**KIRKLEES METROPOLITAN COUNCIL
INVESTMENT & REGENERATION SERVICE**

**DELEGATED DECISION TO DETERMINE APPLICATIONS FOR
CONSENT, AGREEMENT OR APPROVAL REQUIRED BY CONDITION**

Reference No: 2020/44/90823/W

Description: Discharge condition 6 (drainage) on previous permission 2016/91502 for outline application for erection of one detached dwelling

CHIMNEYS

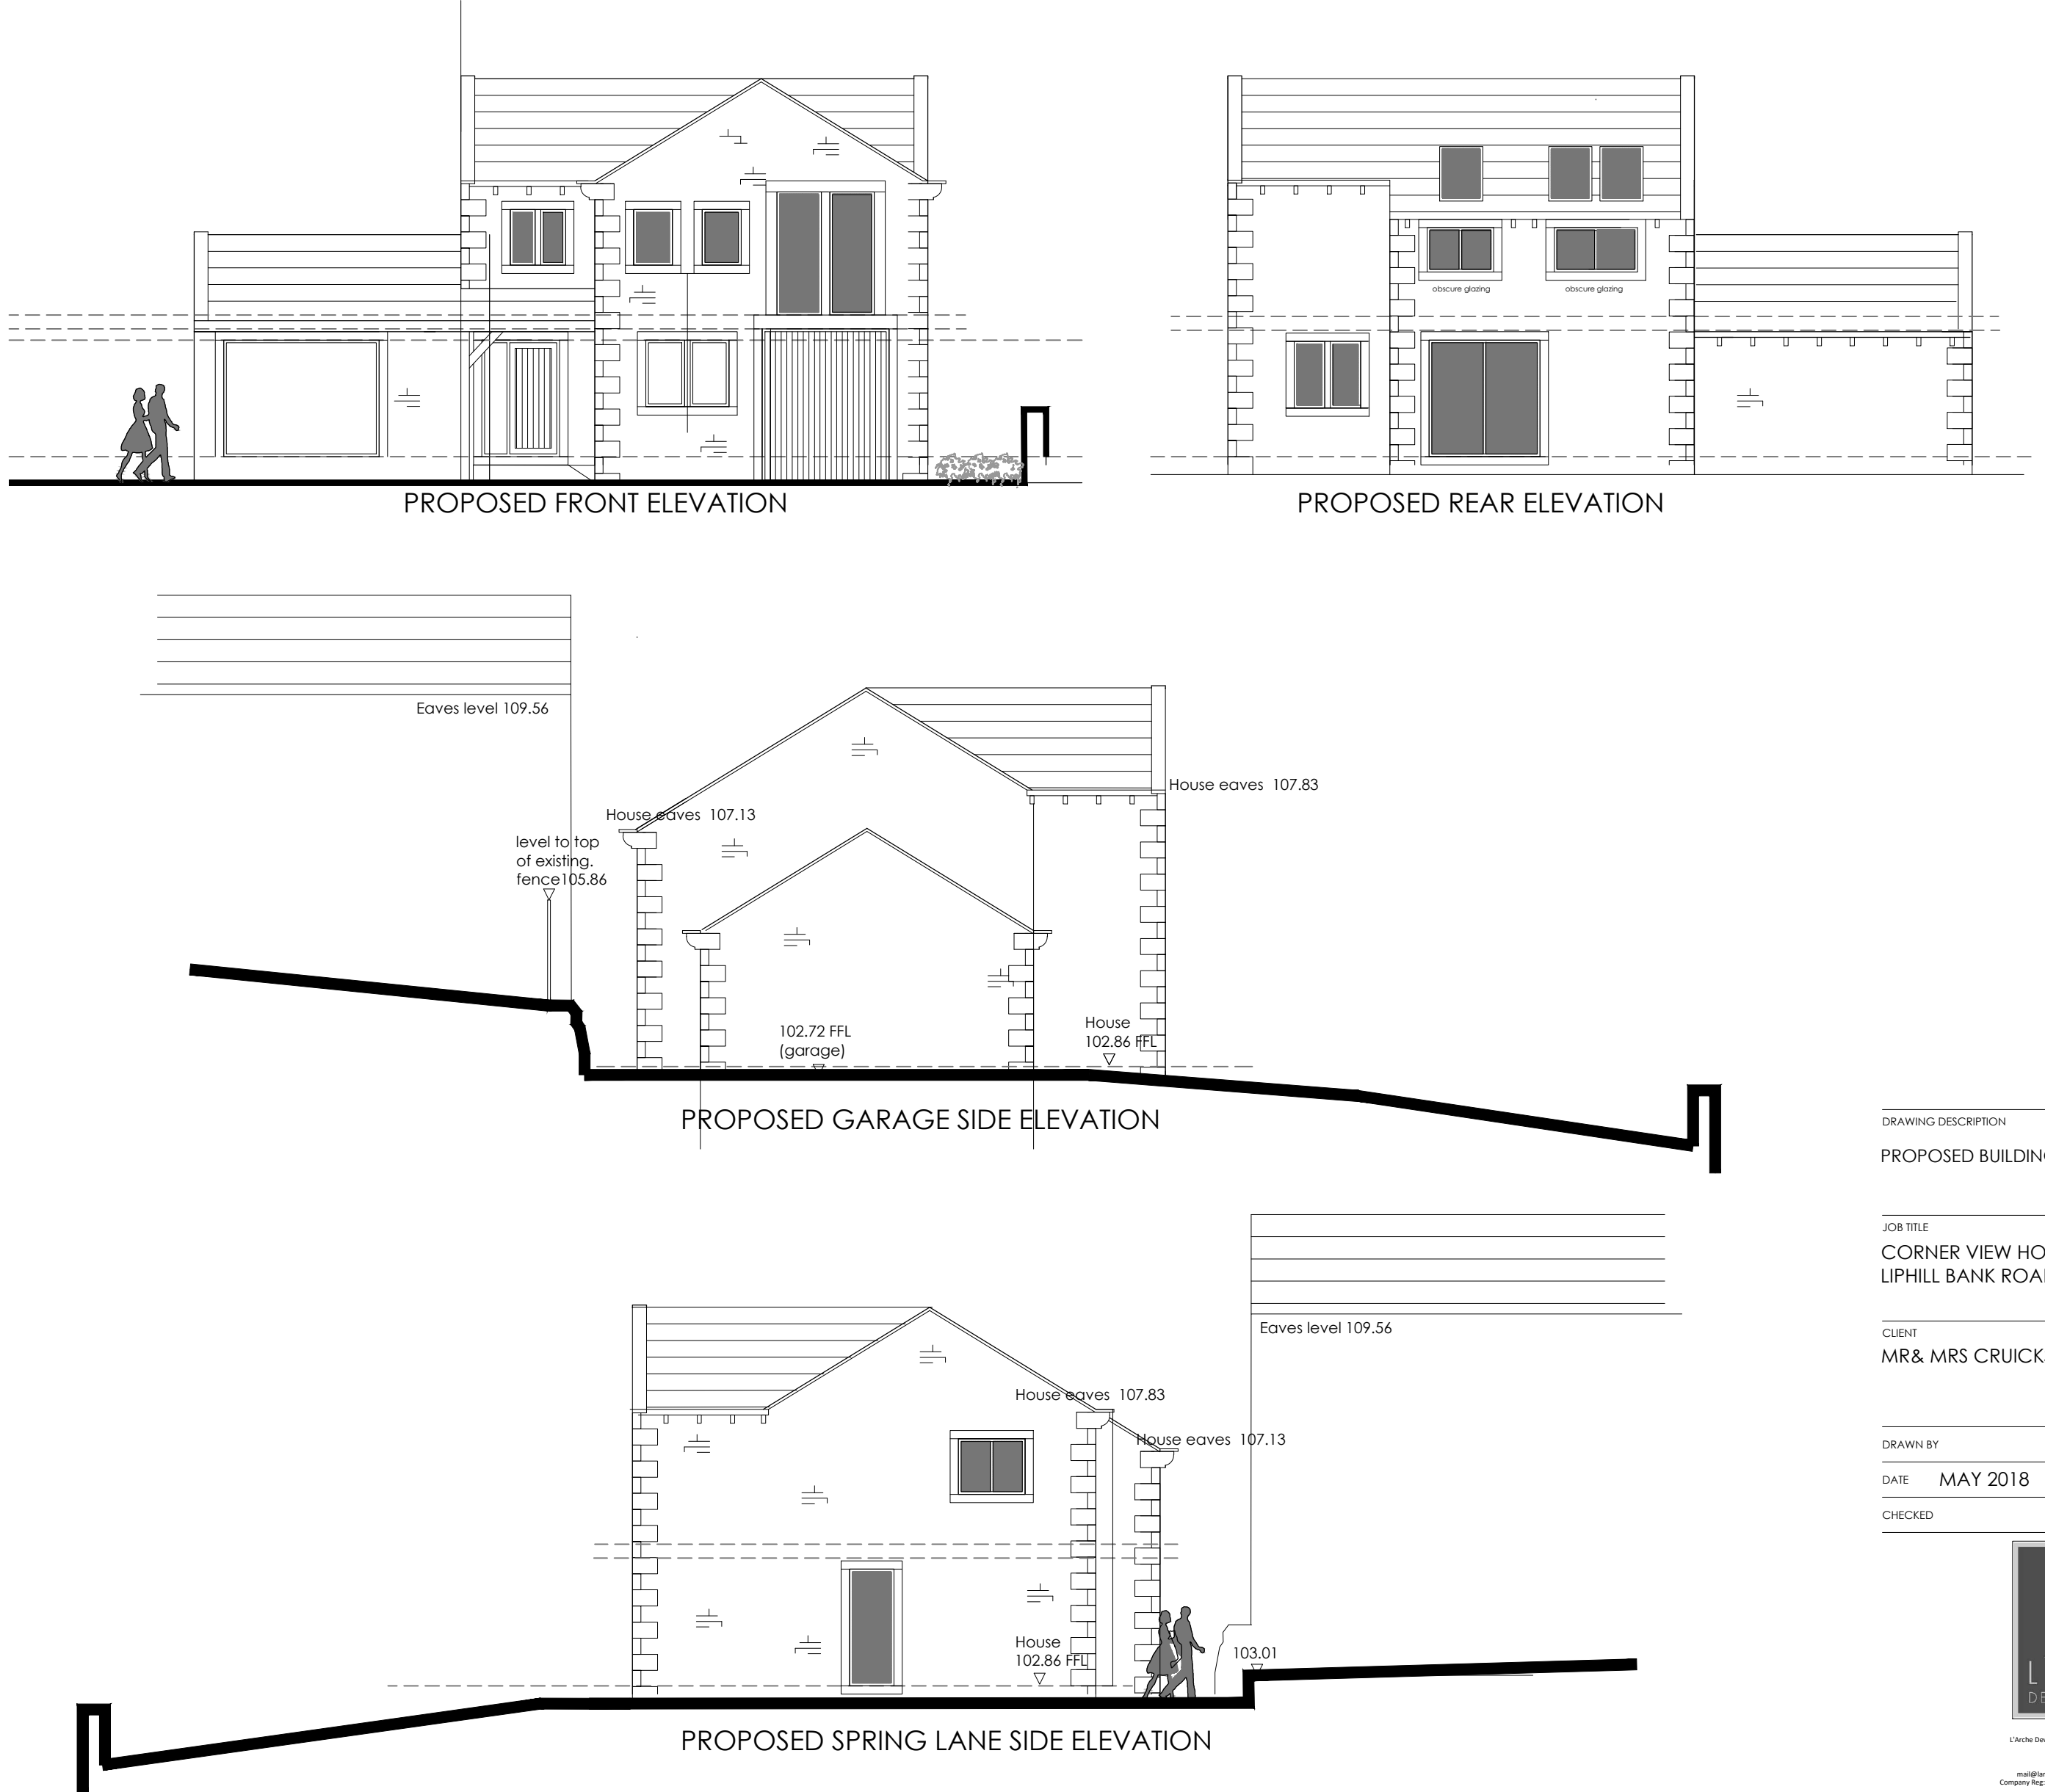
Foul drainage is to be to via Yorkshire Water's combined sewer. This is acceptable given the site's proximity to the network. Such a connection will require permission from Yorkshire Water however officers see no prohibitive reason why this would not be permitted.

Surface water is to be via a percolation tested soakaway. This includes the rain water pipes connecting into the soakaway. Land drainage, with the addition of the soakaway, is to be as existing, excepting the surfaced areas for car parking: this is required by condition 7 to comply with '*the Communities and Local Government; and Environment Agency's 'Guidance on the permeable surfacing of front gardens (parking areas)'*'. It is stated that the surfaced areas will also connect into the soakaway(s), which would comply with the document.

Given the scale and nature of the proposal, the Lead Local Flood Authority are satisfied that the site's drainage will be addressed by Building Regulations. Notwithstanding being a pre-commencement condition, the application is retrospective and Building Regulations have been applied for. Regulation Approved Document H relates to drainage and waste disposal. The applicant has shown the building's competition certificate (ref. 2018/01293) issued by K.C. Building Control. This demonstrates that the drainage has been undertaken in accordance with Building Regulations and is accepted by planning officers.

You have submitted the plan ref. '138 / 2 - 004 Rev. B' as well as the building's completion certificate to discharge condition 6.

I can confirm that the submitted details are acceptable for the purposes of condition 6. It should be noted that condition 6 requires the approved drainage scheme to be provided before the dwelling is occupied and for this approved scheme to be thereafter retained. As such the requirements of the condition cannot be 'discharged'.
